PCU039624

## Submission Form

Epping to Thornleigh Third Track Proposal. Application number SSI 5132.

Figure S.6 Cross-section and elevation - New Cheltenham Station concourse building (see also S.5 for artist's impression)

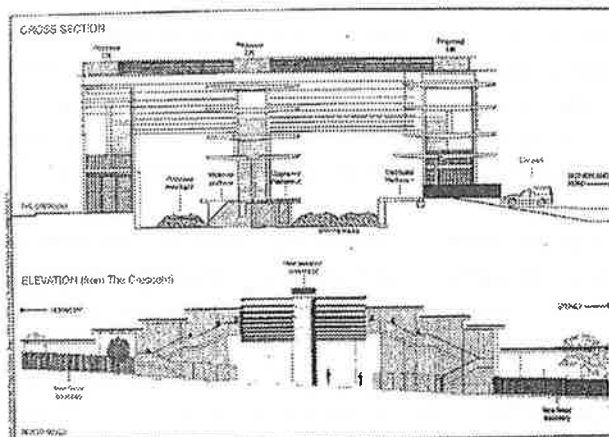
- The proposed redevelopment of Cheltenham Station shows no regard for the HCA. The visual impact of the proposed 13m high glass and steel concourse is totally unacceptable in this HCA.
